Meeting note

Project name	North Shropshire Reinforcement
File reference	EN020021
Status	Final
Author	The Planning Inspectorate
Date	6 August 2018
Meeting with	SP Manweb
Venue	Temple Quay House, Bristol
Meeting objectives	Project update and review of draft documents
Circulation	All attendees

North Shropshire Reinforcement Project: Comments on the draft documents

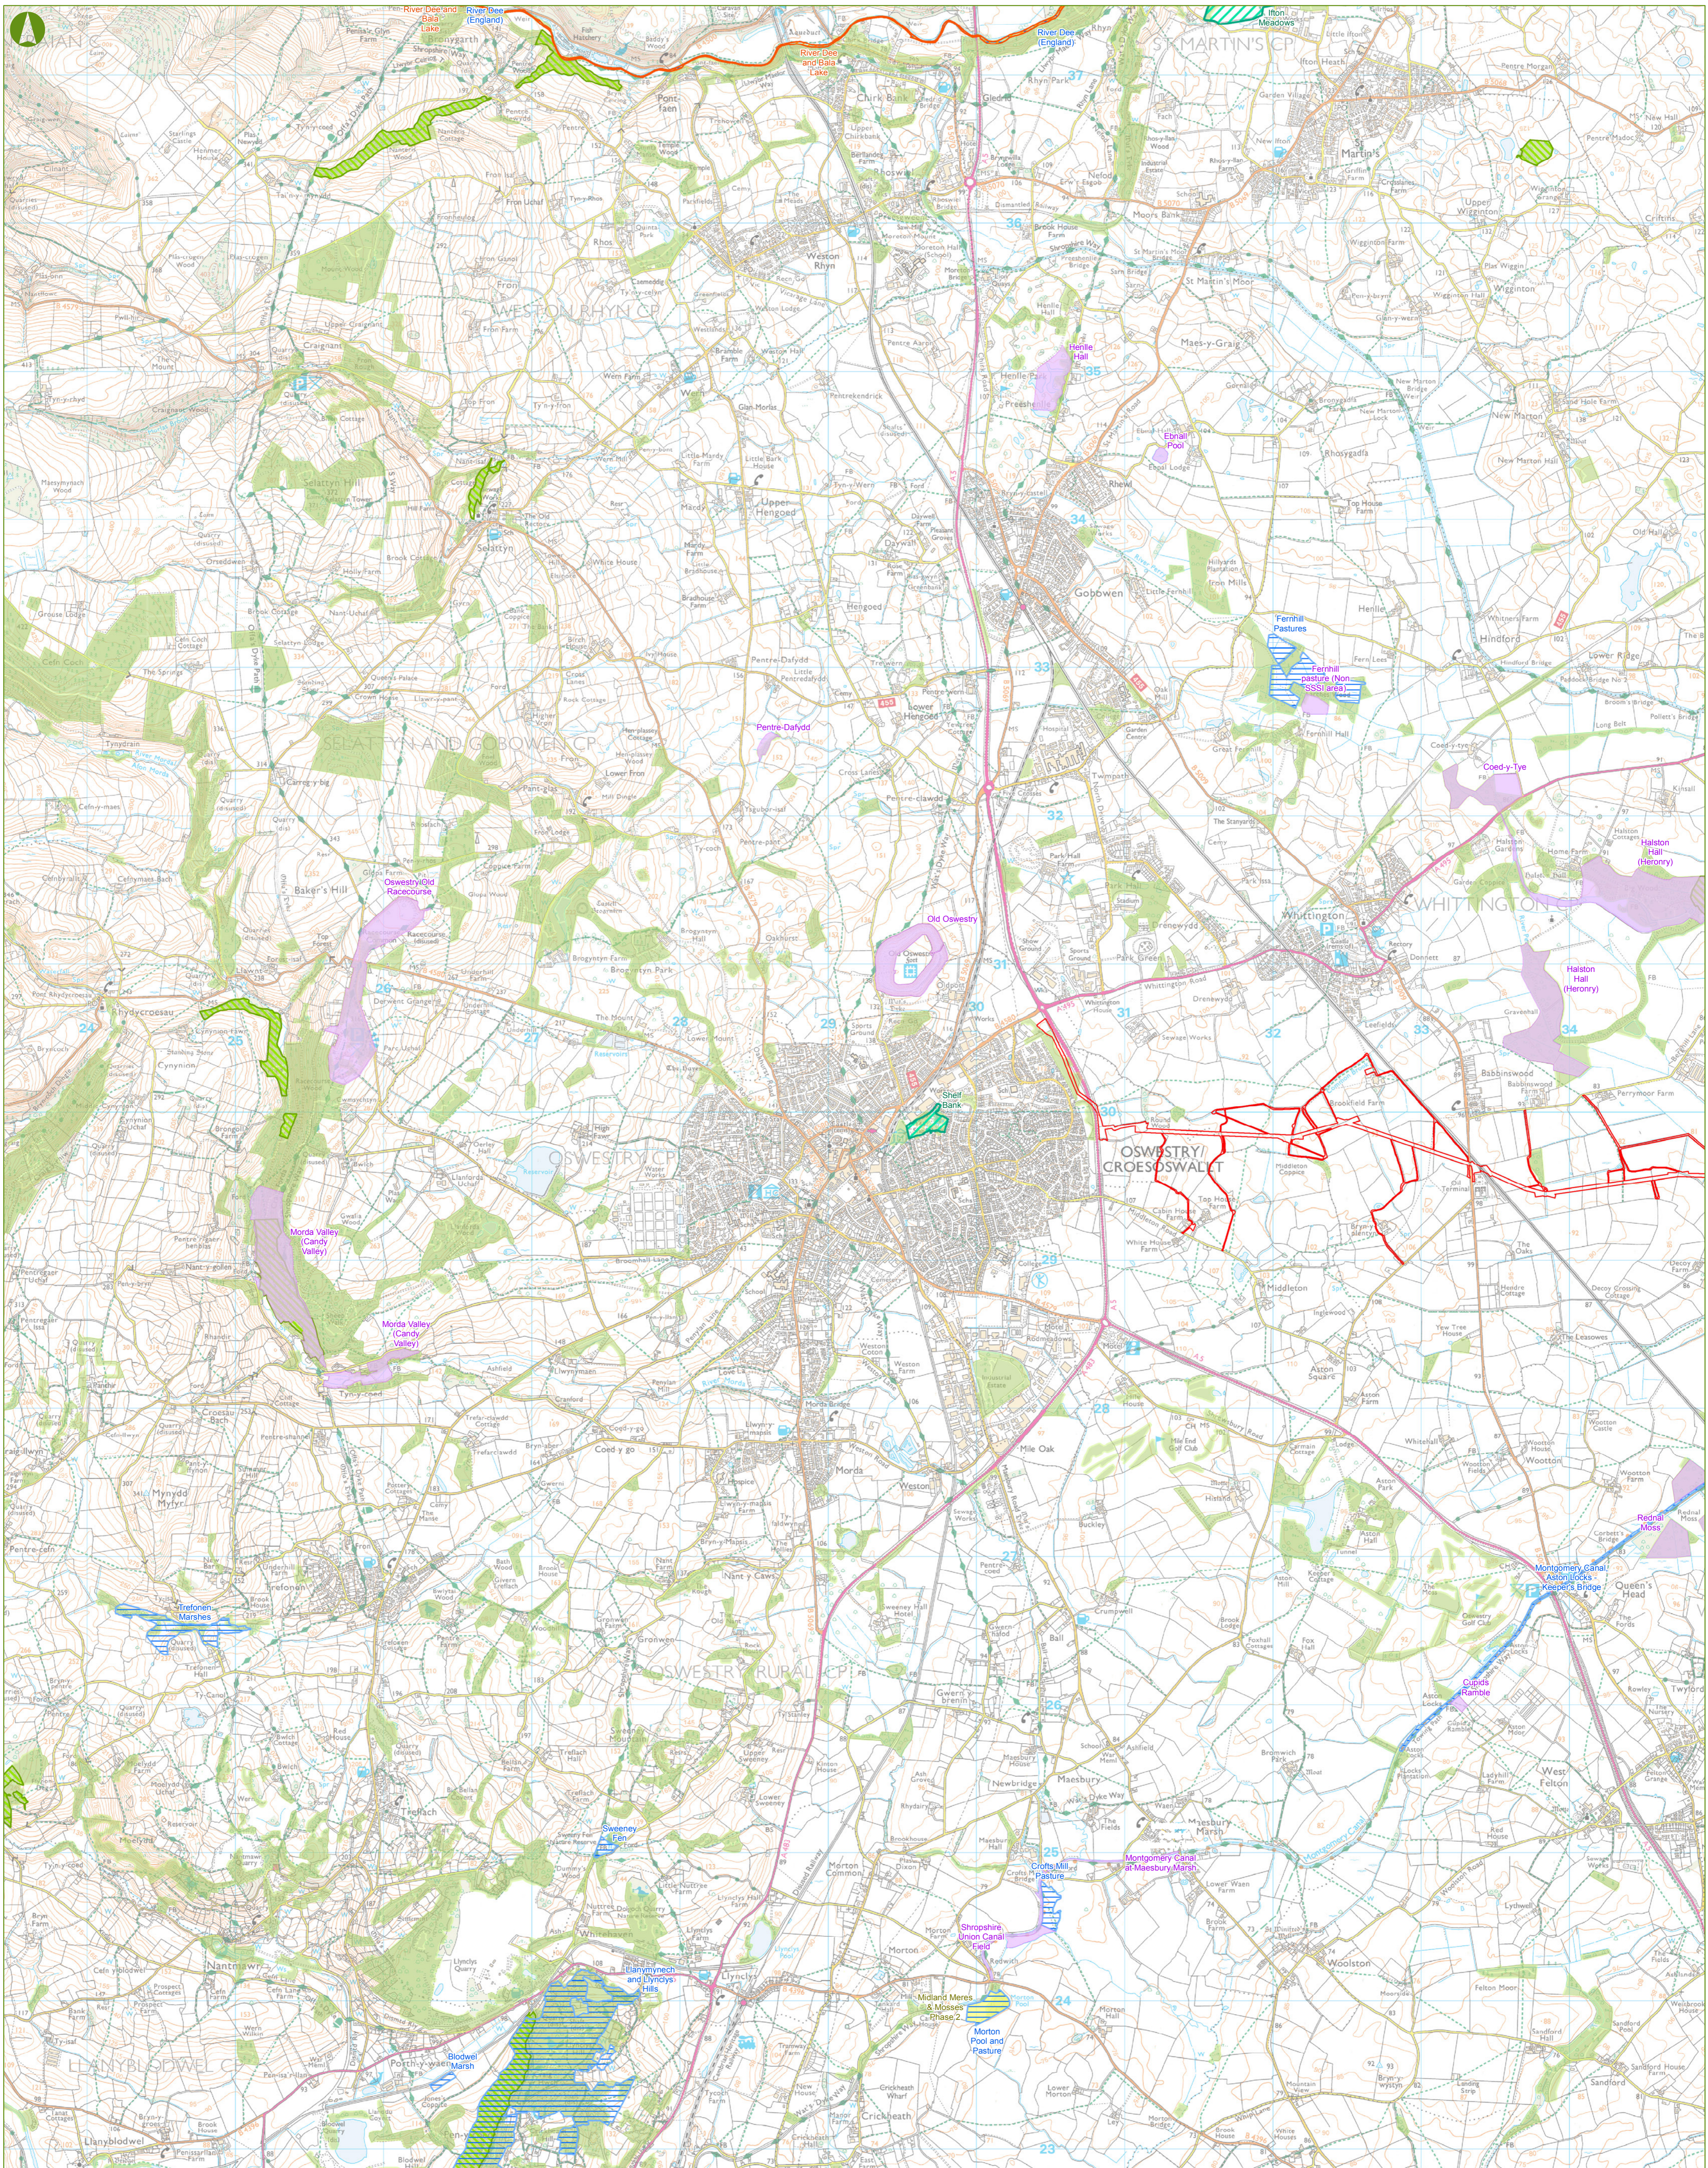
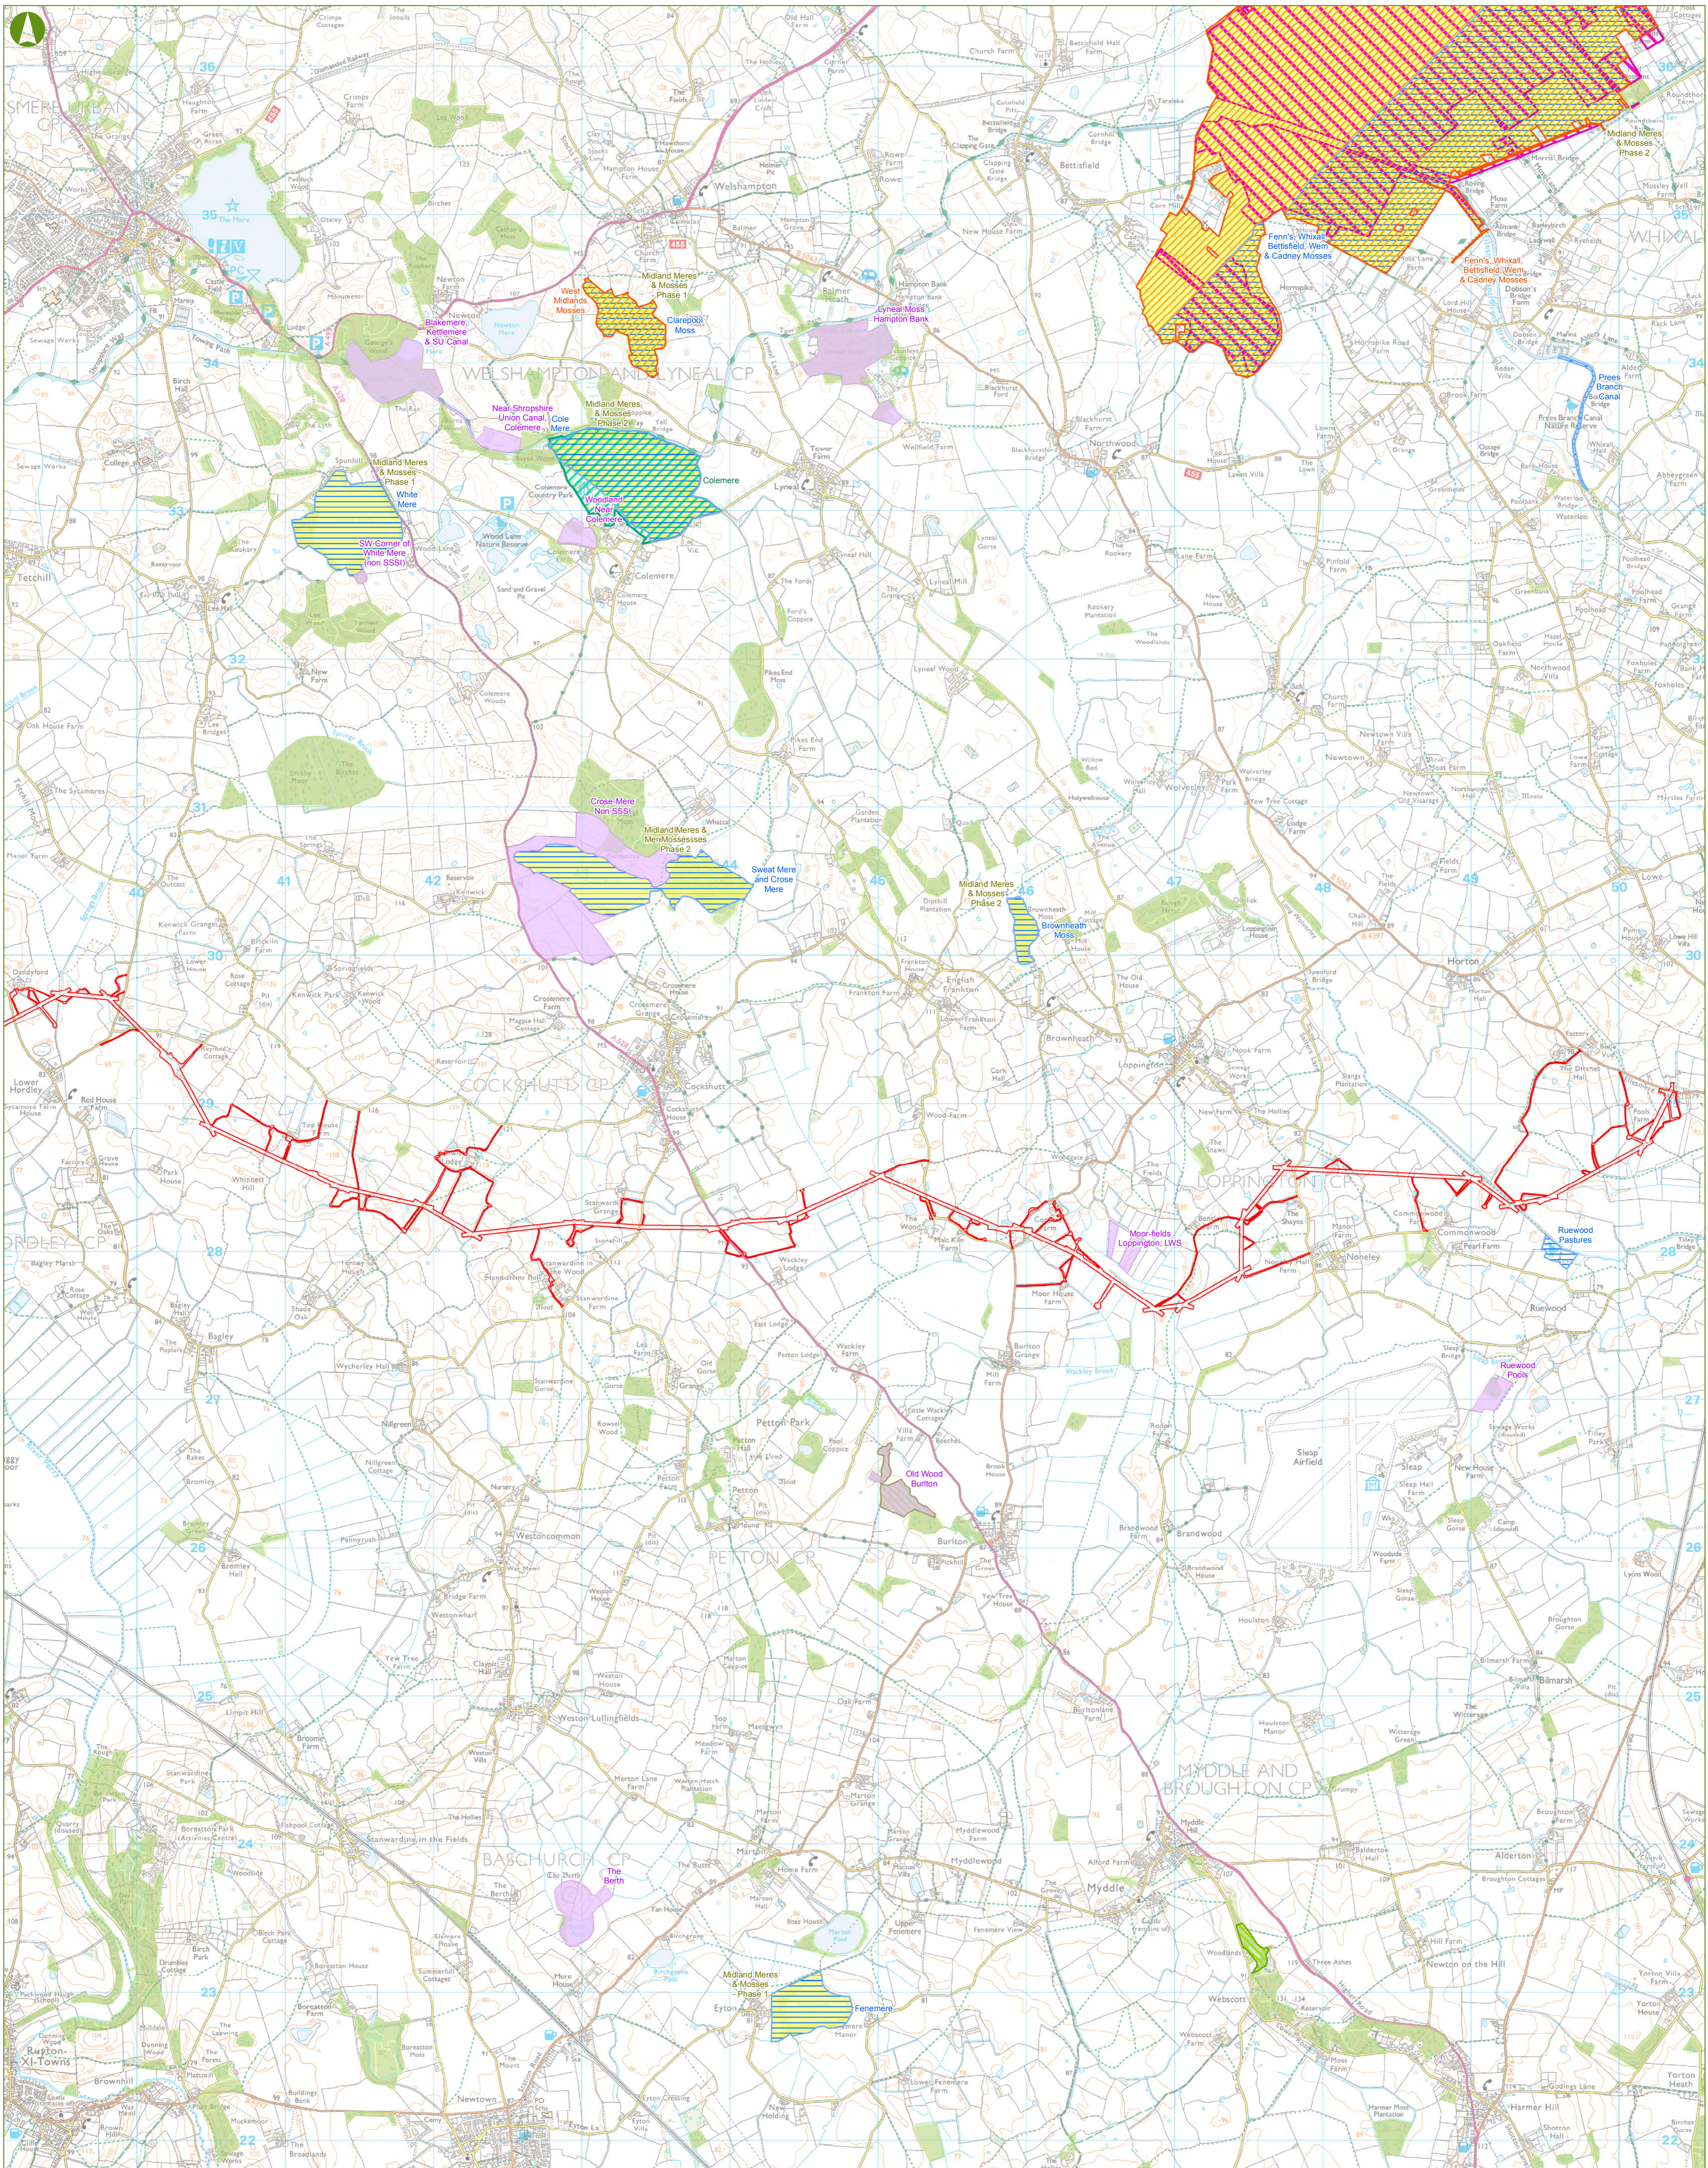
Historic Environment Sites Plan and Nature Conservation Sites Plan	<p>It is noted that these plans are not at the scale specified in the APFP Regulations however the Inspectorate will take a pragmatic approach towards this. We would advise you to justify this departure from the Regulations in the covering letter to your application.</p> <p>It would be helpful if any features that are identifiable by name are identified on the plans, e.g. by number matched to their name in the key/legend.</p>
Key plans	<p>Please ensure that plans that consist of three or more sheets also contain a Key Plan.</p> <p>Linear schemes in particular require a sequence of drawings to show the full extent of the proposals. Where sequenced drawings are provided a key plan and sequence notation should also be provided.</p>
PRoW	<p>These should be clearly marked so they can be cross referenced with the draft DCO.</p>
General Advice	<p>Please refer to advice contained in Advice Note 6 How to submit your application which provides advice on file referencing for each plan or document including, for example, the title, a unique plan or document reference and the appropriate APFP Regulation 5(2) paragraph number to which the plan relates.</p> <p>Any plans, drawings or sections should be consistent with the requirements set out in The Infrastructure Planning (Applications: Prescribed Forms and Procedure) Regulations 2009.</p>
